From: Sue Howell <Sue.Howell@arun.gov.uk>
Sent: 13 December 2019 17:15
To: Planning.Responses <Planning.Responses@arun.gov.uk>
Cc: Raymond Cole <Raymond.Cole@arun.gov.uk>
Subject: RE: Planning Consultation on: BE/103/19/RES

Comment from Greenspace

APPLICATION NO: BE/103/19/RES

Description of Works: Approval of reserved matters following the grant of BE/77/16/OUT and BE40/18/PL for 50 No. residential units with associated roads, drainage & other related infrastructure.

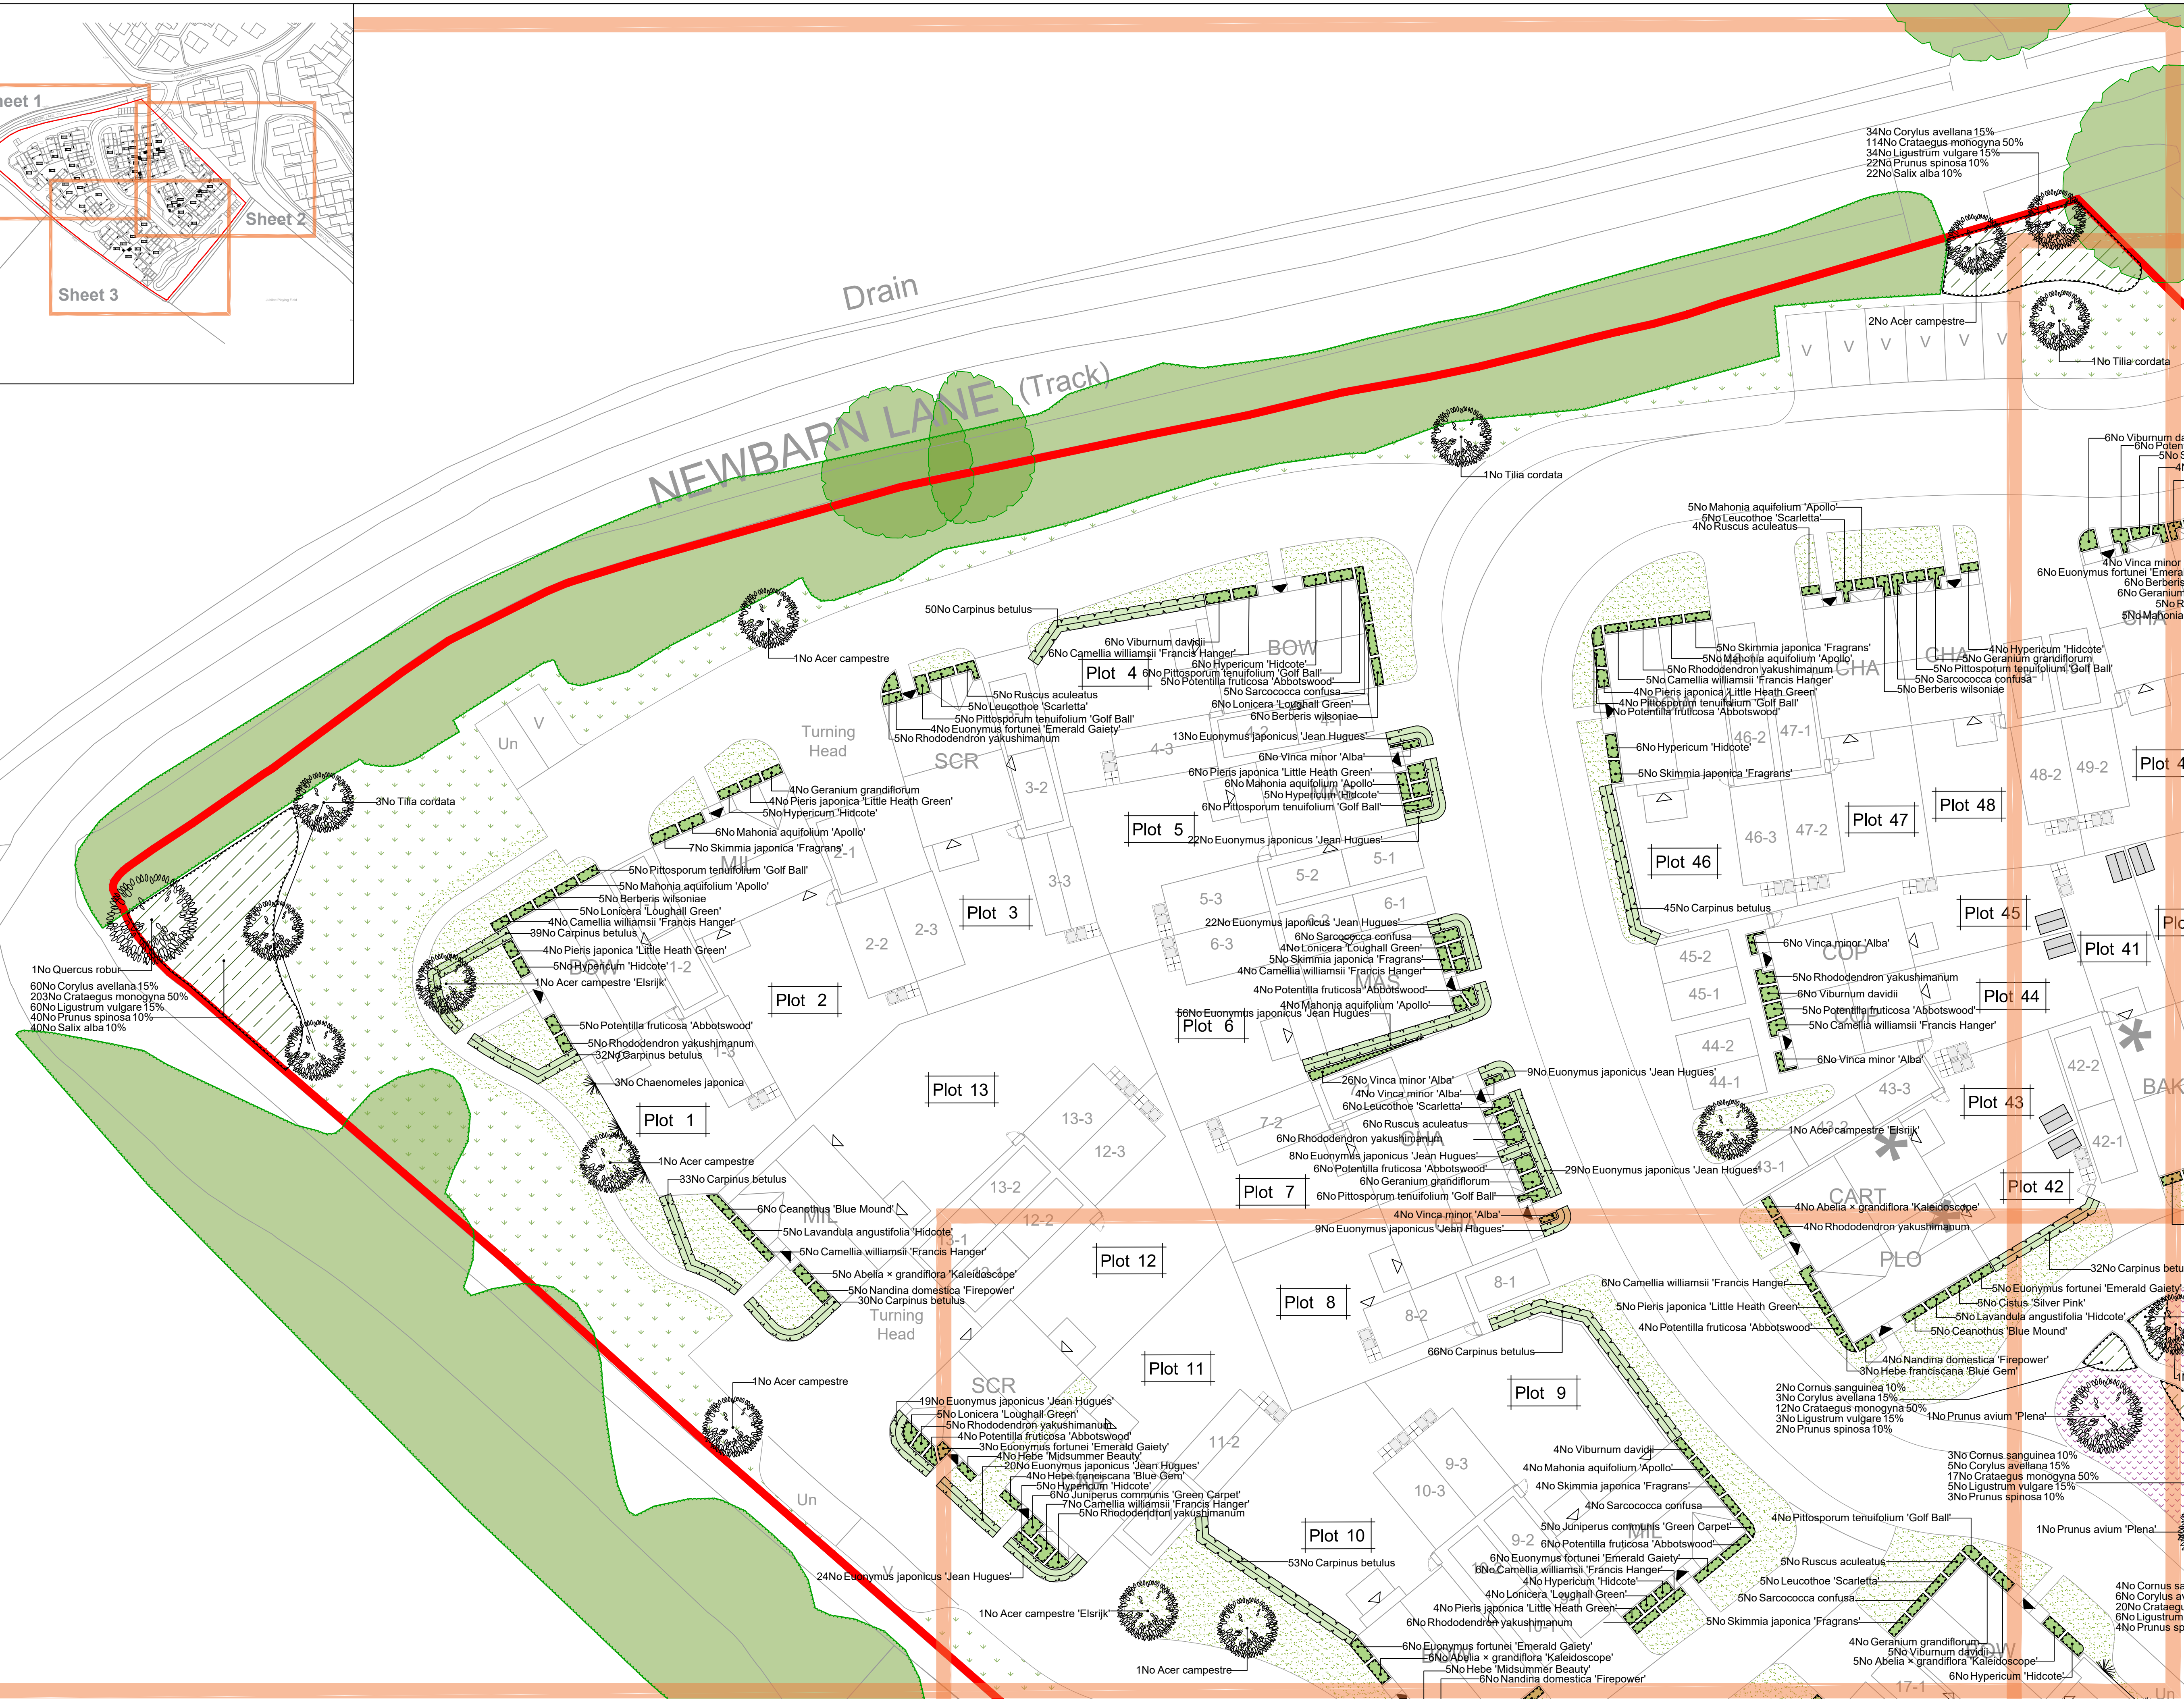
The proposals now presented concerningly show a much narrower and now no longer continuous POS perimeter belt, much enlarged and elongated areas of SuDS and no direct connection with the ditch crossing to land beyond the site. The loss of this continuous green belt around the site will be detrimental to the linking of the green areas and detrimental to wildlife corridor establishment and potentially decrease biodiversity establishment across the site.

The layout proposes dwellings now very close to the south east corner on the boundary, with no footpath now possible in this area.

Clarification to be provided regarding the quantity of POS excluding any areas of SuDS and unusable pockets of ground, now being proposed and the compliance with our SPG open space standards guidelines? The full implication of the SUDS within the POS needs to be provided including its future management and maintenance. The recommendation that these are subject to RoSPA or similar organisation inspection should be noted. Indication must be provided as to whether these are likely to be wet or dry areas; this has implications where situated near to residents and play areas. Where they are to remain wet for long periods their safety must be assessed regarding the close proximity of these to residential areas. The indicated SuDS, including any potential swales, wet balancing ponds, reed beds and wetland areas should be designed as beneficial wildlife, amenity and landscape features and incorporated as part of the overall open space/landscaping scheme for the development. A larger area of POS to surround this feature would allow it to blend within its surrounds and good design principles should be employed to ensure that this is realised.

The loss of the perimeter belt compromises the cycle and footway potential and the continuous link between Jubilee Playing Fields, Eastern and Winston Crescent, which needs to be provided.

- Confirmation of POS areas and play offer to be provided
- A quality design process needs to be employed which allows for the incorporation, enhancement and protection of existing features
- Perimeter and buffer areas and wildlife habitat zones along with SUDS provision to be re-addressed in line with the outline framework plan and these principles effectively assessed and incorporated.
- Pathway/cycle route and access provision to be allowed for and incorporated back into the design
- Indication of future management proposals to be provided
